**REF: 24/00245/OUT****Location: South Lodge, Fringford Road, Caversfield,  
Bicester, OX27 8TH**

21 February 2024

#### **Comments on outline plans provided**

Land Use Parameter Plan

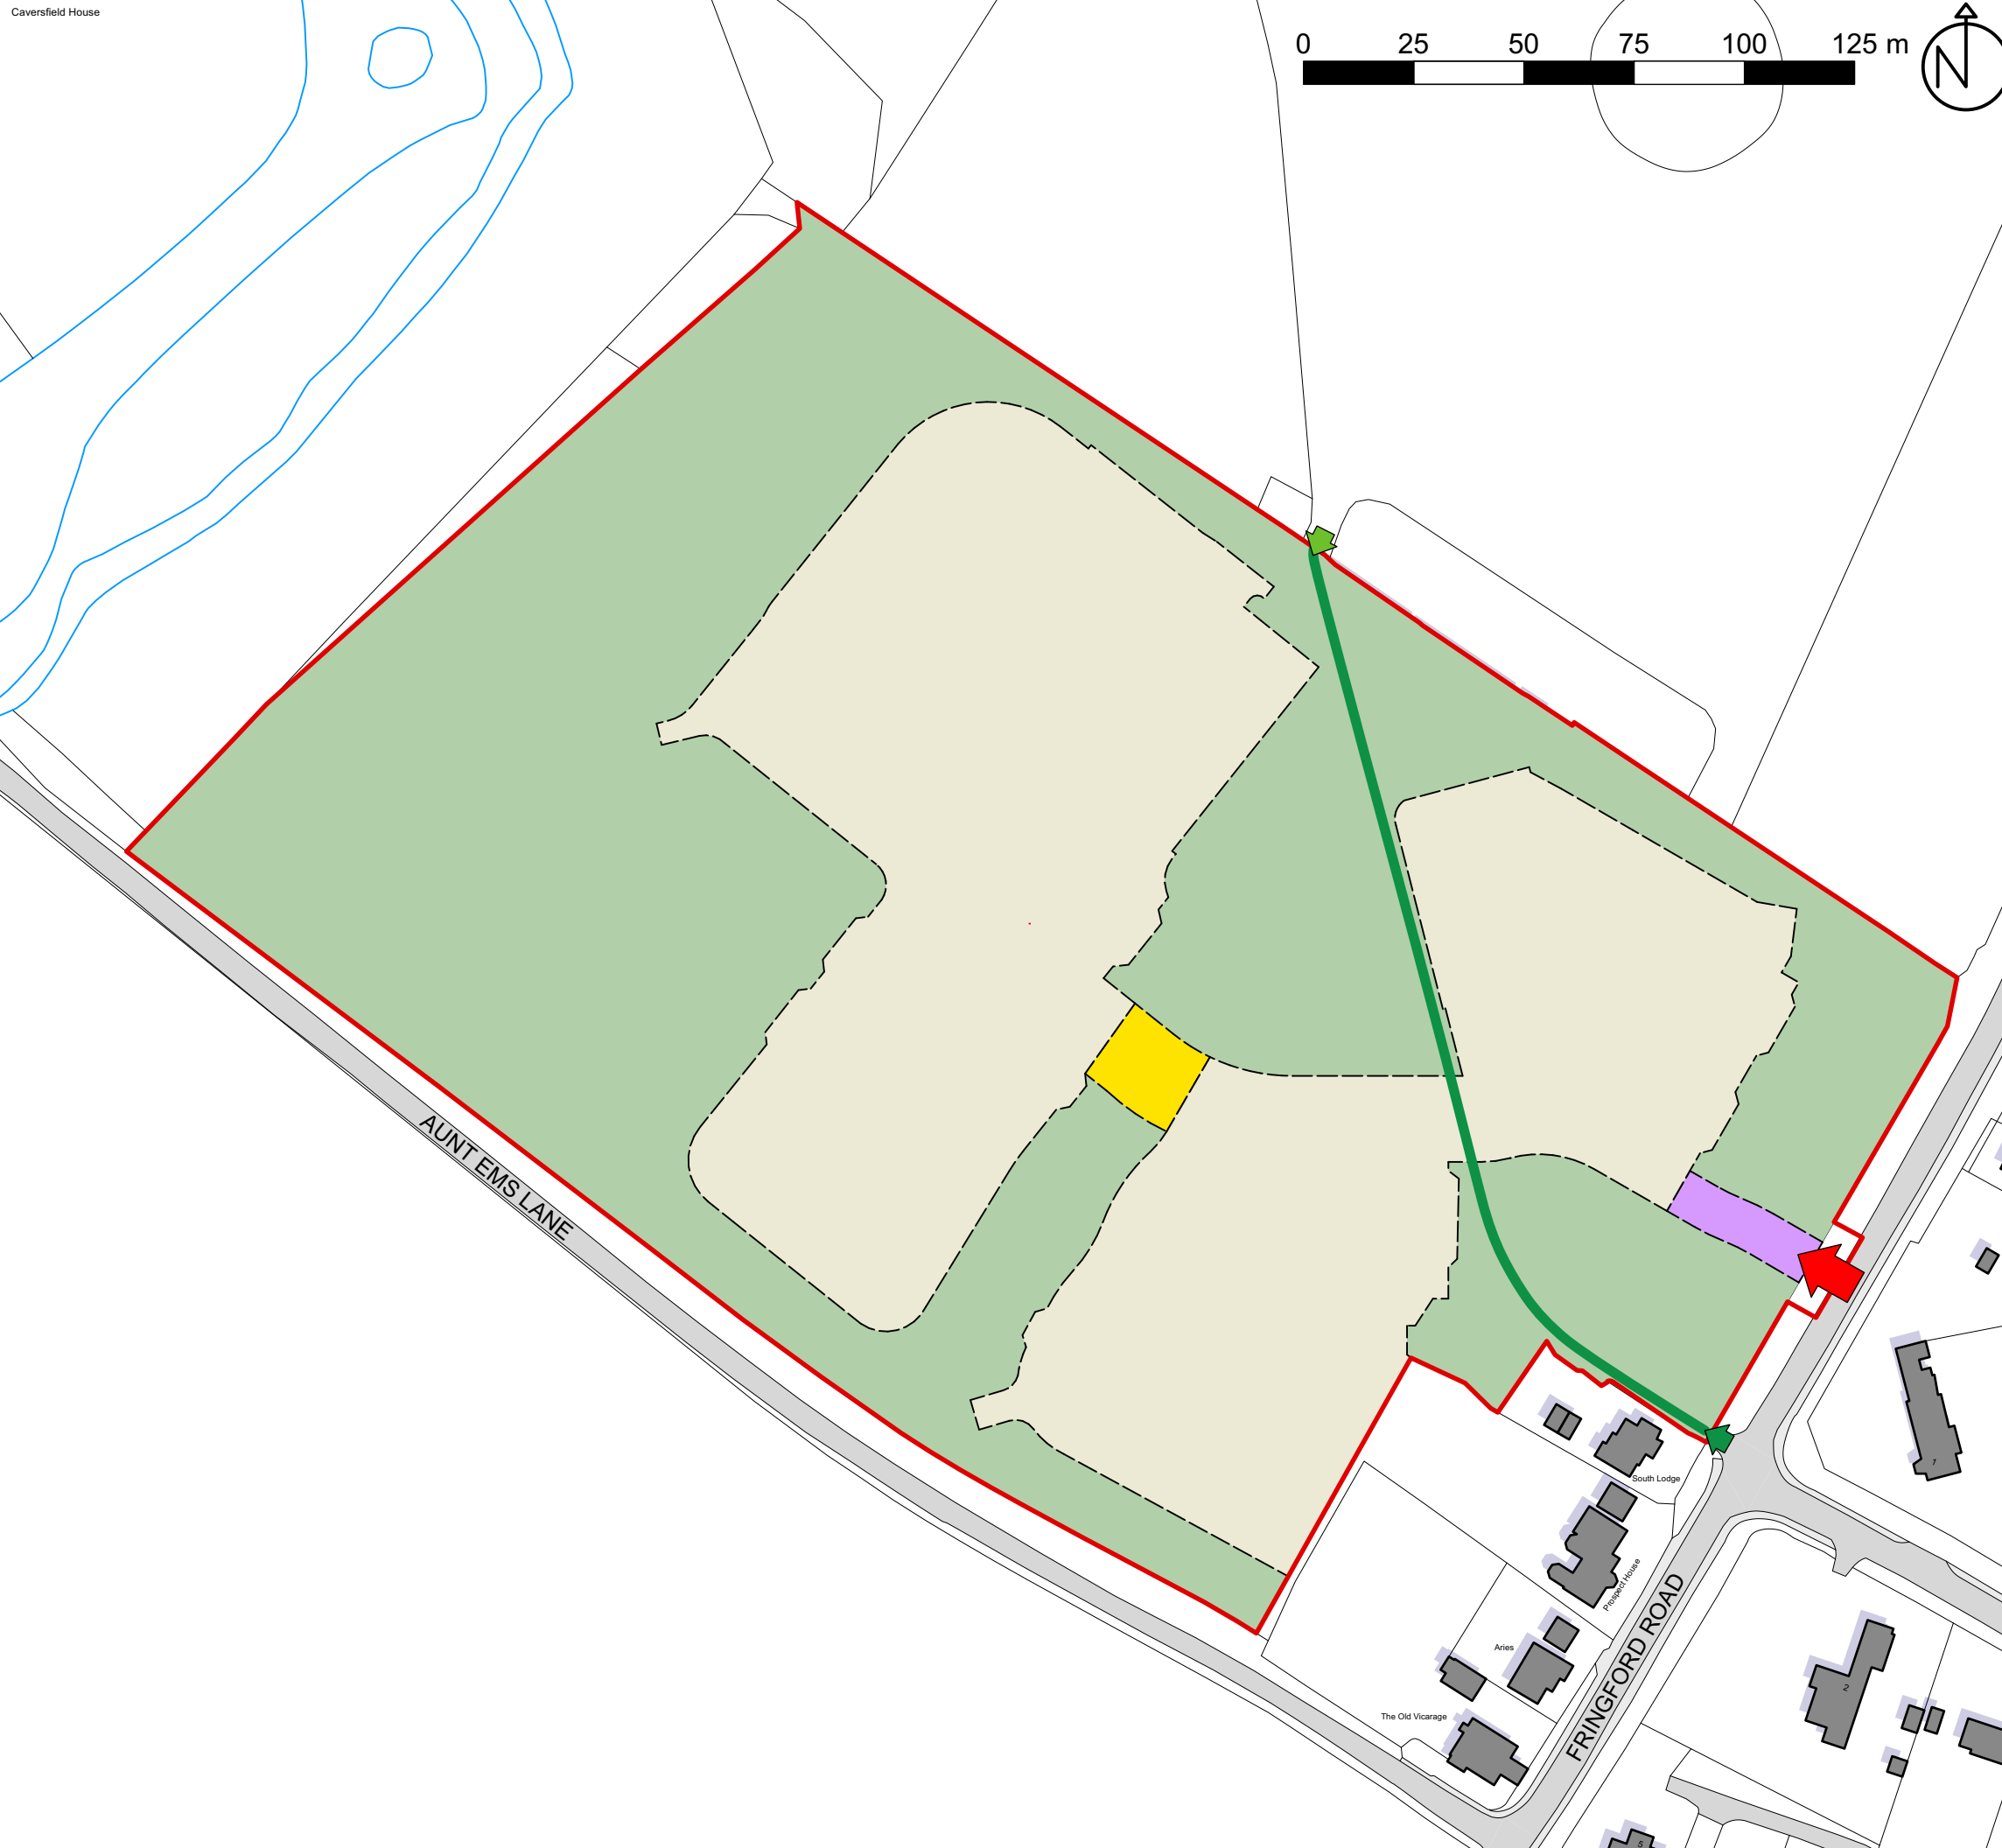
- Pedestrian and cycle routes (such as seen with the “historic track alignment”) must have vehicle mitigation measures to prevent unauthorised vehicular incursion at the point they meet the highway. Proposals risk vehicles and motorbikes/mopeds using these tracks, undermining community cohesion and creating tension. I note bollards are proposed, but there needs to be more effective vehicle mitigation in appropriate locations. The eastern block is again problematic, with a pedestrian/cycle path very vulnerable to cars being driven on it to drop shopping and children at the front door for example.

- The large areas of green open space within this development will be very vulnerable to unauthorised encampments or vehicle enabled antisocial behaviour. Comprehensive enclosure must be provided to prevent vehicles gaining access to the green space, utilising landscaping or physical barriers to prevent access.

- Plans must indicate how the vulnerable side/rear boundary of existing residential dwellings will be protected, as the proposals currently open up and expose these vulnerable boundaries to new public open space which does not currently exist for these properties. Point 18 “Open grassland” on the labelled illustrative masterplan is an area of concern, with vulnerable residential boundaries exposed, with accessible green space that has no clear ownership, function or purpose. SLOAPS must be avoided, with all green spaces having clear purpose.
